| Application number: 2024/90597   |                                                                                  |
| What is the application for?:    | Demolition of existing conservatory and erection of sun room to side with roof t |
| Address of the site or building: | 4, Wrigley Court, Netherton, Huddersfield, HD4 7ED                               |

Proposed block plan (1:500)

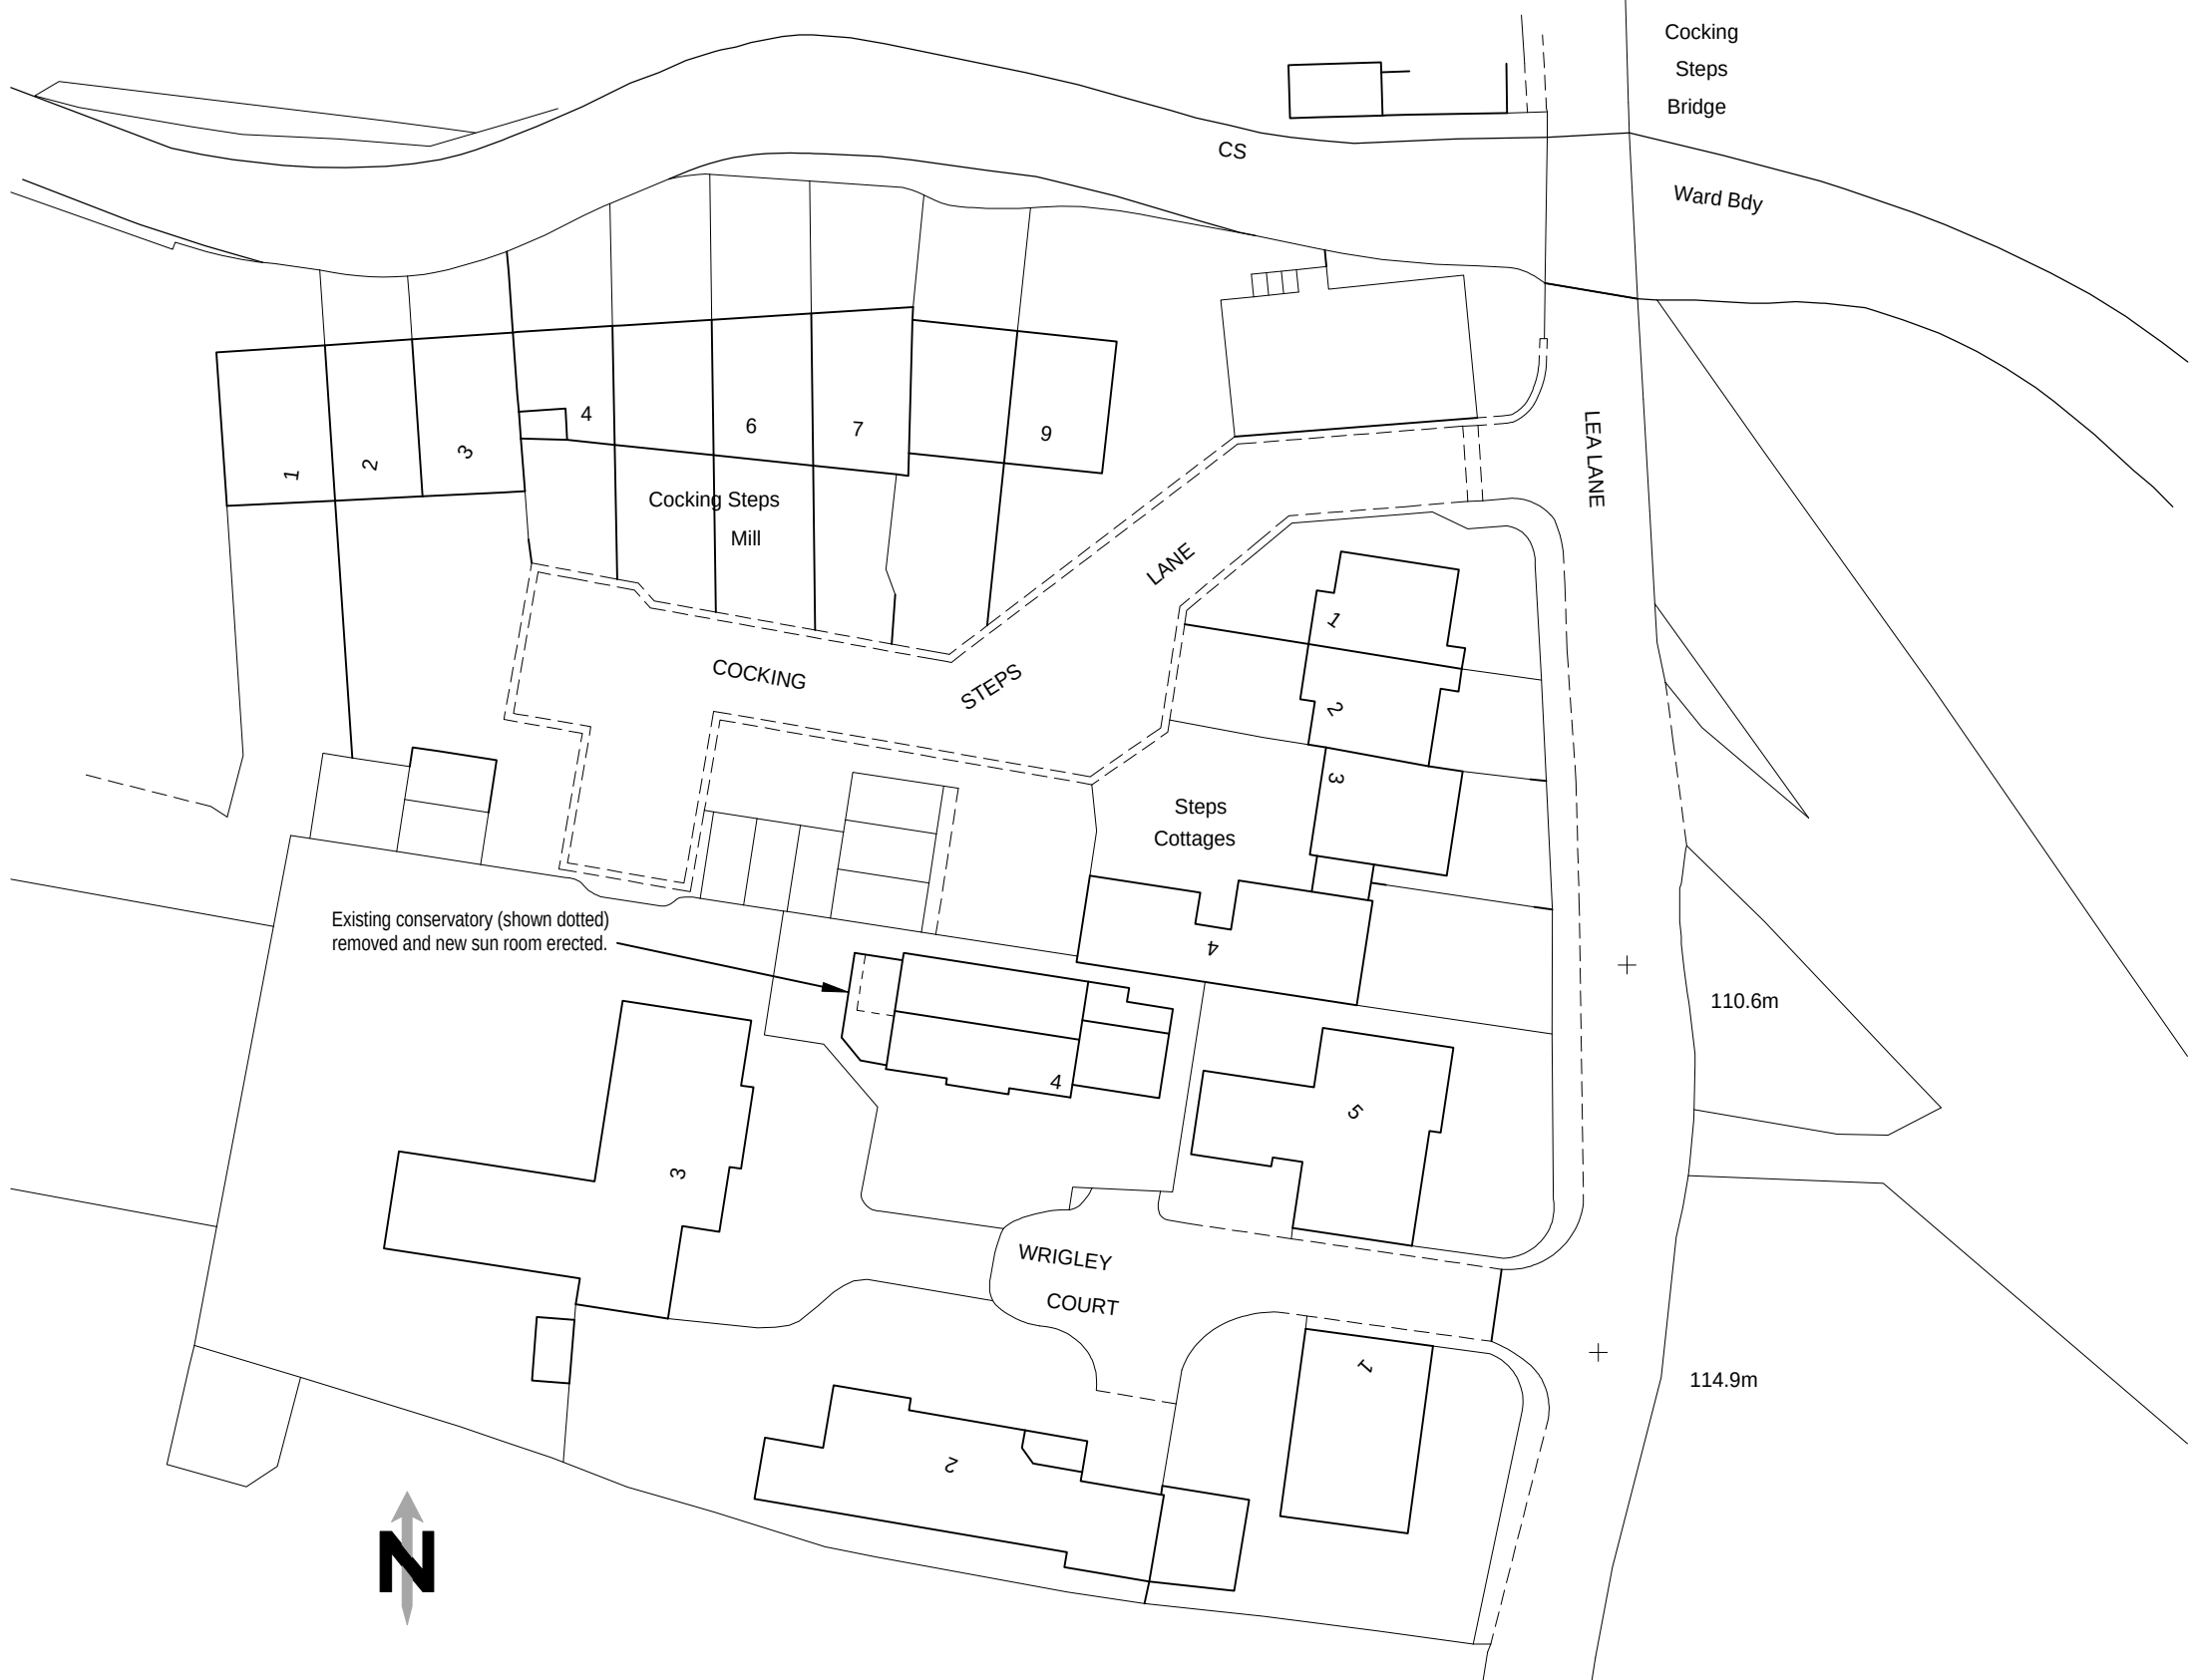
| <p>The roof terrace would affect the privacy of nos 1-3 Cocking Steps Mill, because it would overlook the top front windows of nos 1-3, their front gardens, and the entrance of no 1. Users of the roof terrace would be able to look directly into these areas. The front gardens of the Mill are used a lot in good weather, at exactly the times when the roof terrace would be used.</p> <p>Noise of socialising on the roof terrace would be audible everywhere on Cocking Steps Lane. Past experience (of noise from a hottub) indicates that sound reaches up and down the whole lane.</p> <p>We are keen to preserve both the privacy, and the peace and quiet, of the lane, for the sake of the environment generally, as well as for our own sake. Visitors to the lane comment at once on its privacy and quietness in a crowded, noisy world. But the roof terrace would be in effect a balcony overlooking its neighbours from a height, insensitive and intrusive in a development (Wrigley Close) considerate to its neighbours.</p> |     |
